CITY OF ALBUQUERQUE

Re: Speculative Coffee
2509 San Mateo Blvd NE
Traffic Circulation Layout
Engineer's/Architect's Stamp **05-20-2019** (H17D116)

Based upon the information provided in your submittal received 07-11-2019, the above referenced plan cannot be approved for Building Permit until the following comments are addressed:

DETAIL 1 -
DIRECTIONAL ARROW
SCALE: 3/4" = 1'-0"

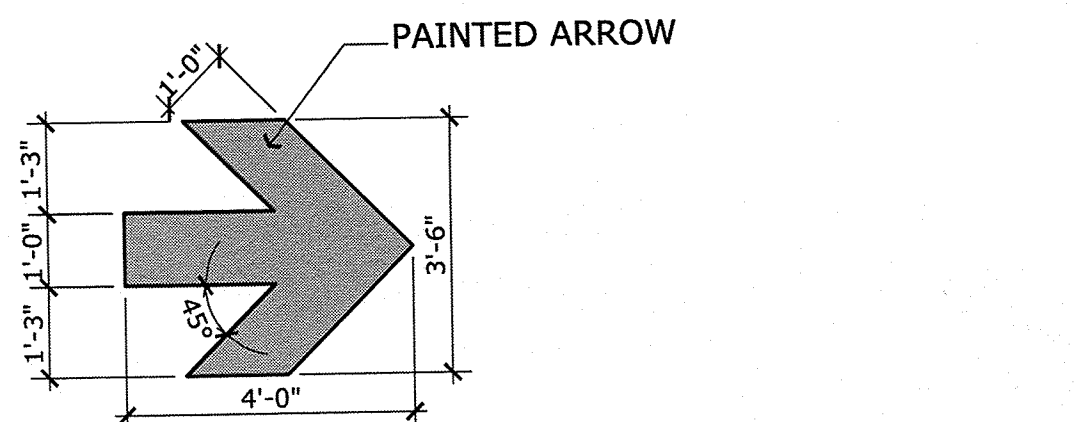
7. provide a copy of refuse approval.
8. One-way vehicular paths require pavement directional signage and a posted **"Do Not Enter"** sign at the point of egress. Please show detail and location of posted signs.

DETAIL 2 - BIKE RACK
SCALE: 3/8" = 1'-0"

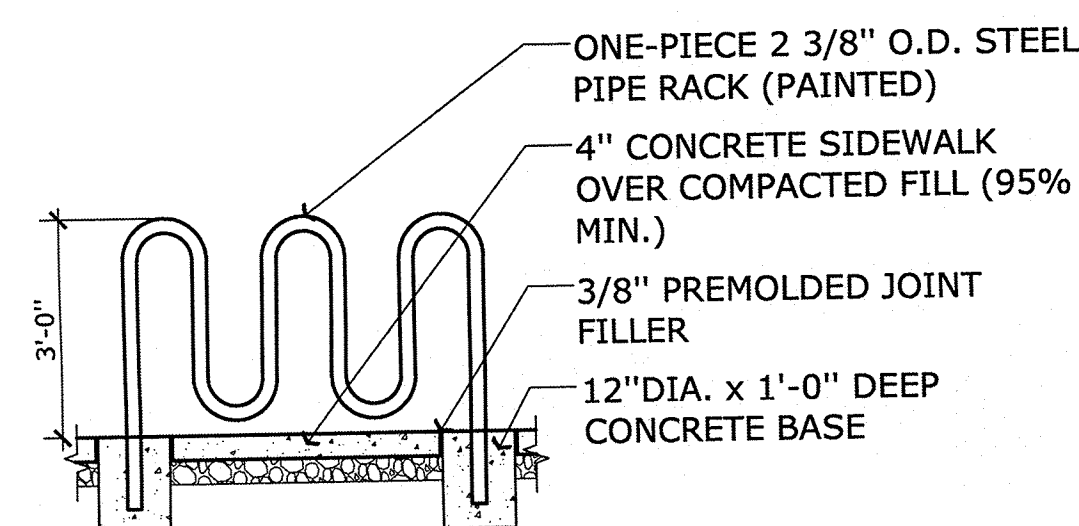
6. Bicycle Parking should be in the form of a corral or other vertical feature that clearly demarcates the space as intended for bicyclist only. Corrals are most appropriate at street corners.

SHEET NUMBER
A-1.0

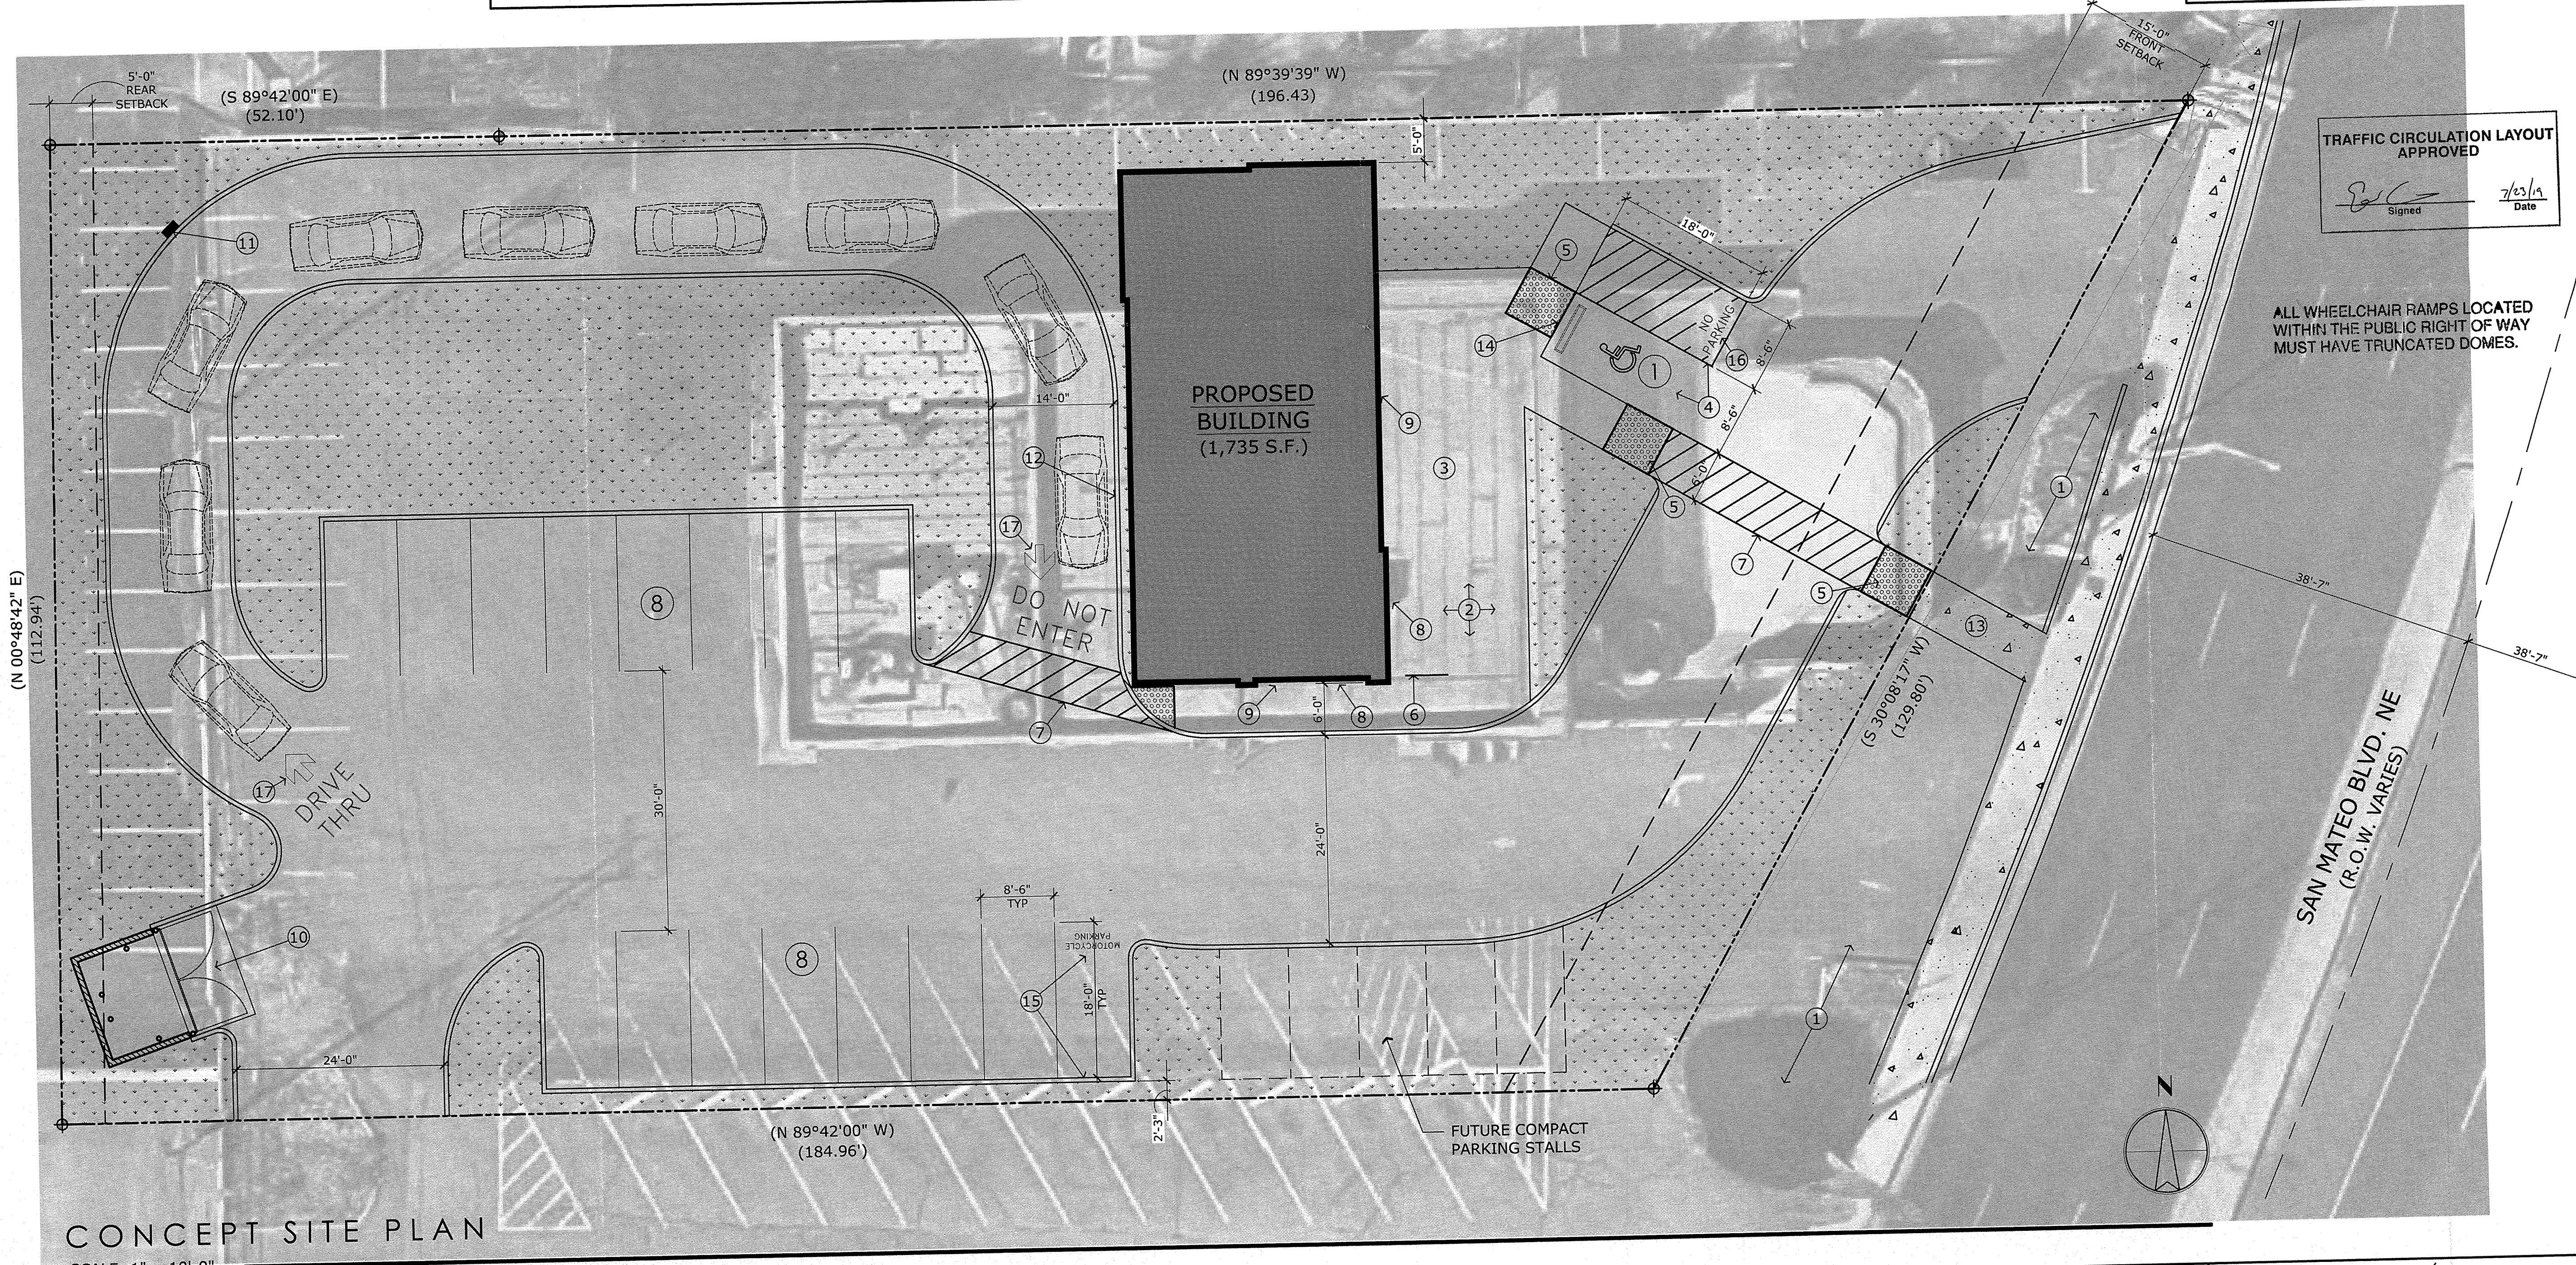
1. Please show a vicinity map showing the location of the development in relation to streets and well known landmarks.
2. The handicap accessible spaces must include an access aisle. Van accessible aisles should be 8ft wide; all others should be 5ft wide.

3. The ADA accessible parking sign must have the required language per 66-7-352.4C NMSA 1978 **"Violators Are Subject to a Fine and/or Towing."** Please call out detail and location of HC signs.

4. The ADA access aisles shall have the words **"NO PARKING"** in capital letters, each of which shall be at least one foot high and at least two inches wide, placed at the rear of the parking space so as to be close to where an adjacent vehicle's rear tire would be placed. (66-1-4.1.B NMSA 1978)

5. Motorcycle parking spaces shall be designated by its own conspicuously posted upright sign, either free-standing or wall mounted per the zoning code.

9. Shared Site acces: driveways that straddle property lines, or are entirely on one propertybut are to be used by another property, shall have an access easement.
